# The Planning Inspectorate

Our Ref: EN020021

### **Application by SP Manweb for an Order Granting Development Consent for the Reinforcement to the North Shropshire Electricity Distribution Network**

#### **Advice following issue of decision to accept the application for Examination**

© Crown copyright. All rights reserved.  
2017 Licence number 100019036

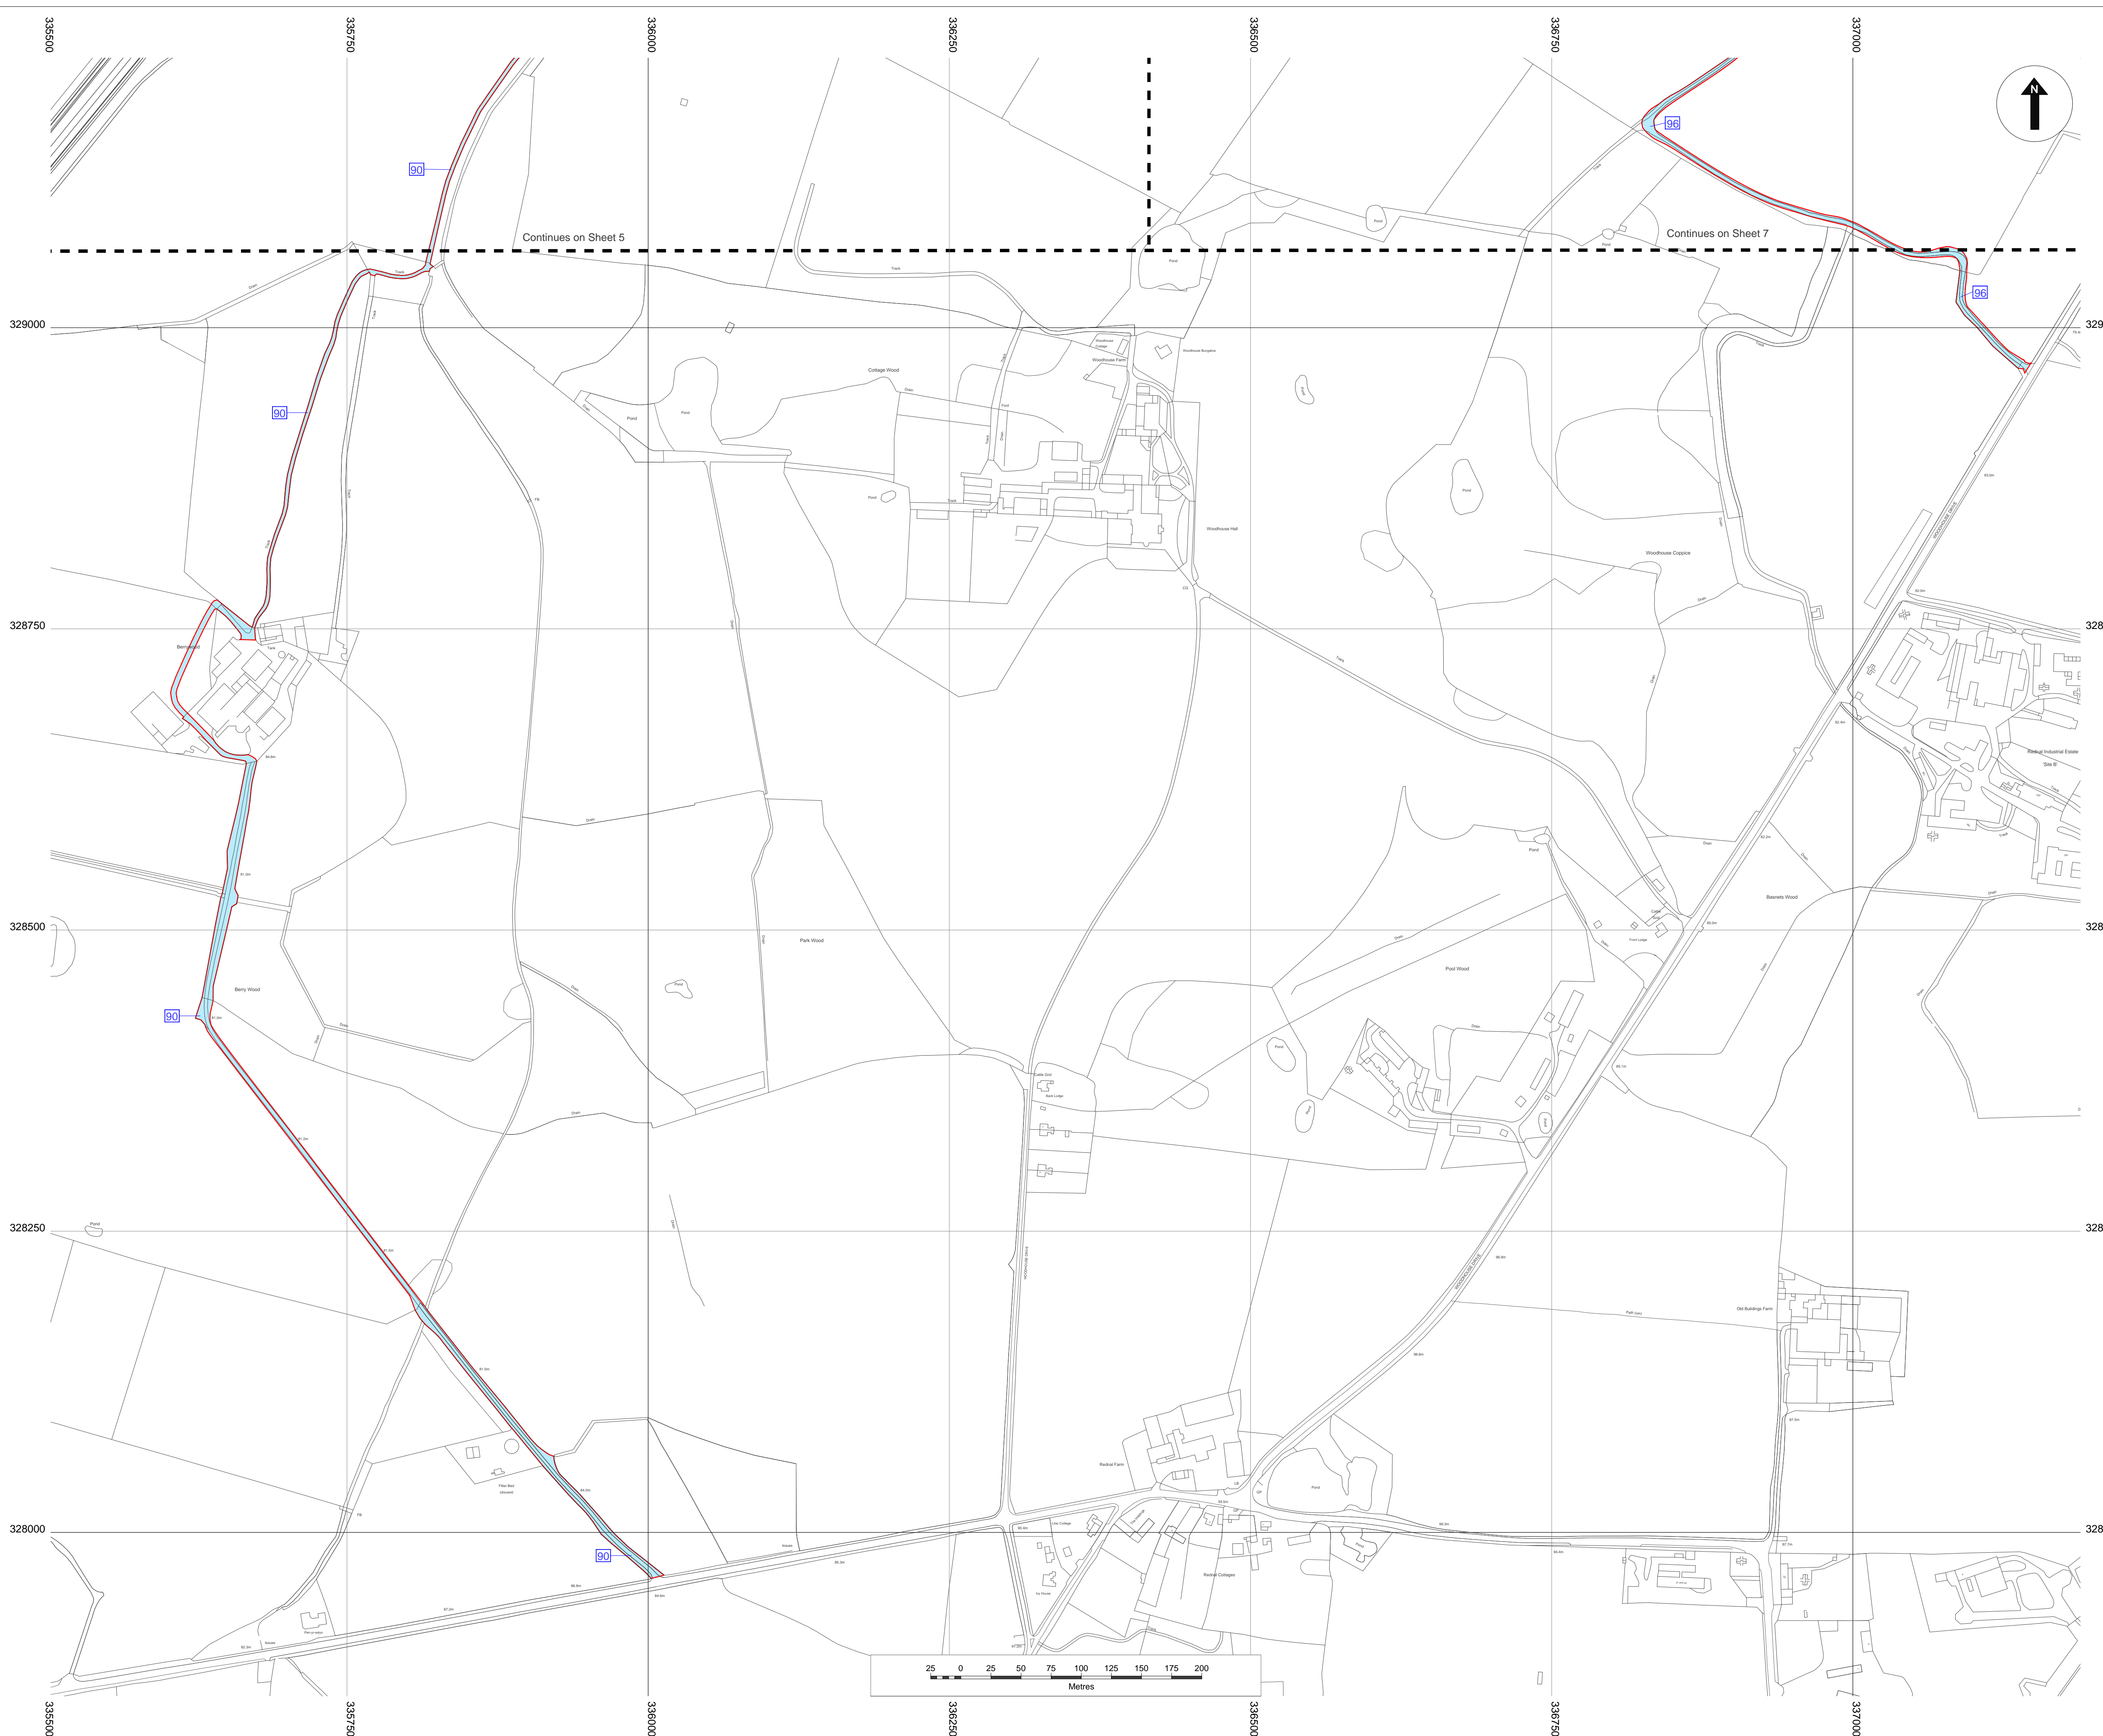
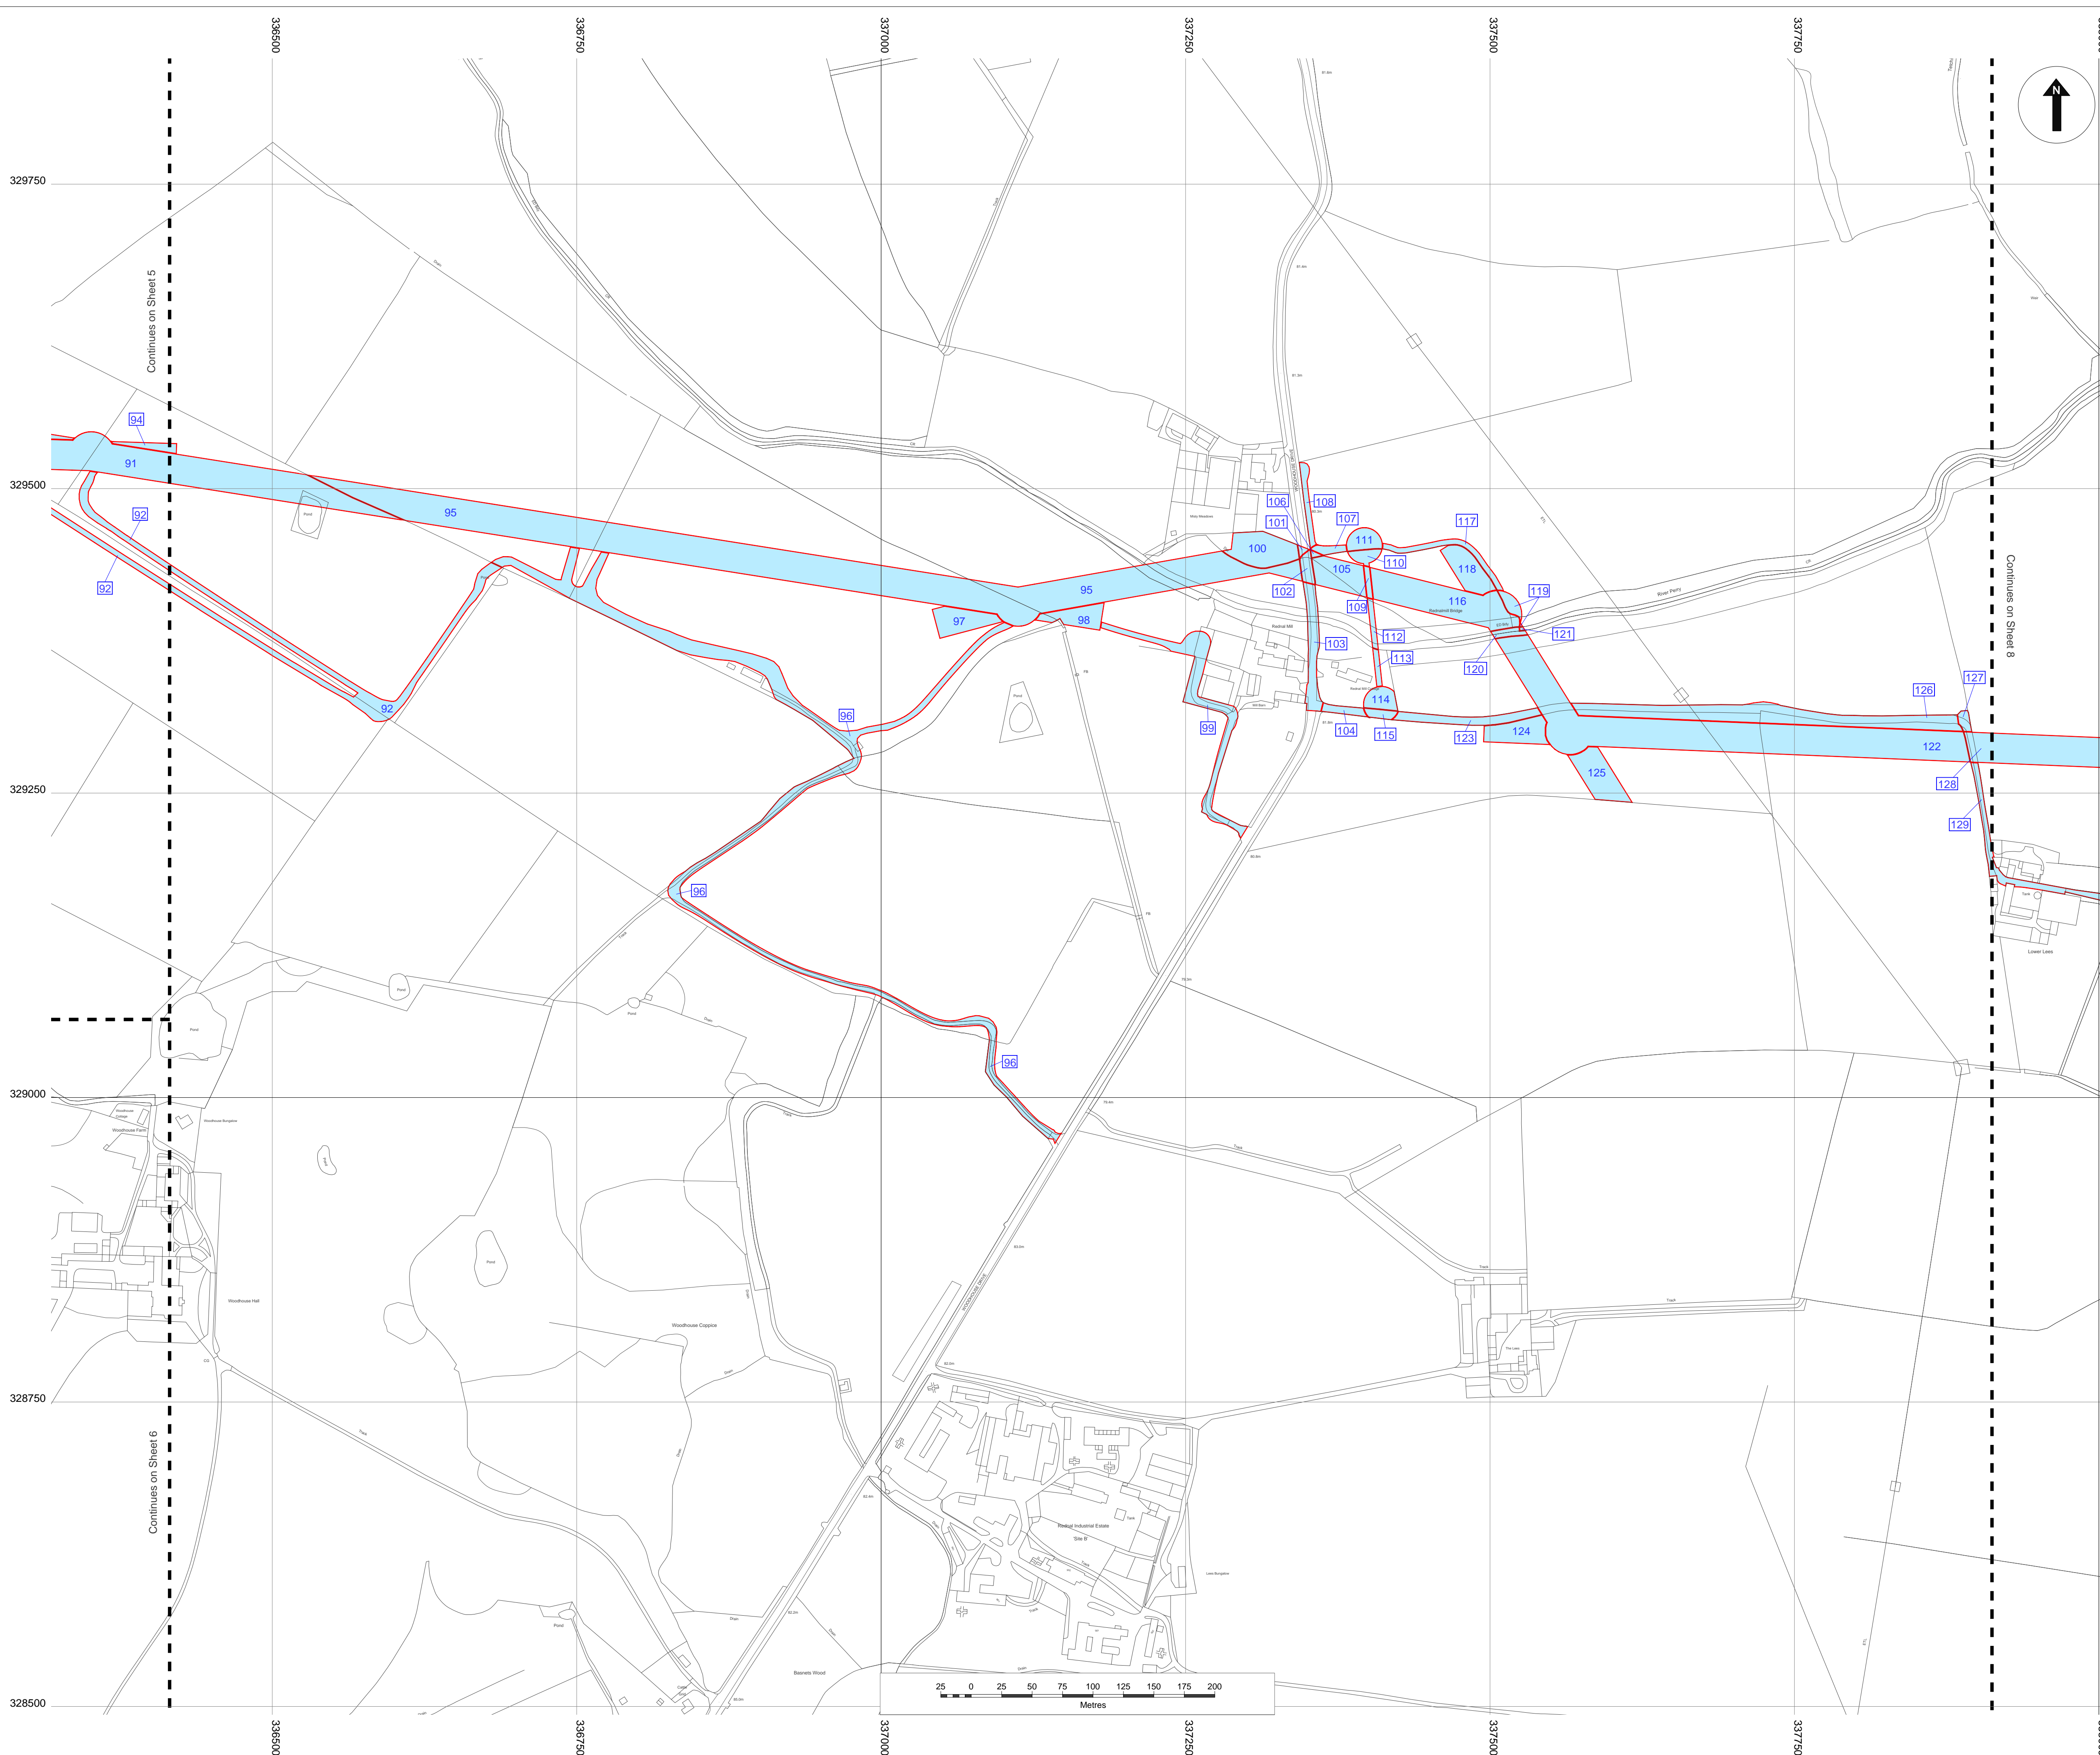
The plots coloured yellow on the Land Plans are described in the legend as “*Order Land – temporary rights (construction only) to be compulsorily acquired, and temporary use of the land, and in relation to which it is proposed to suspend or extinguish easements, servitudes and other private rights*”. It is not clear from this whether it is temporary possession or compulsory acquisition of permanent rights to be used temporarily which is intended by the Applicant in relation to specific plots. The Applicant is therefore requested to clarify the precise rights it is seeking over each plot marked yellow on the Land Plans.

Some discrepancies were found between the colour of some plots on the Land Plans and the description of rights the Applicant is seeking over that land in the Book of Reference. The Applicant is advised to carry out a full review of the Land Plans and the Book of Reference and ensure that all land interests are clearly informed about the precise nature of rights the Applicant is seeking over their land.
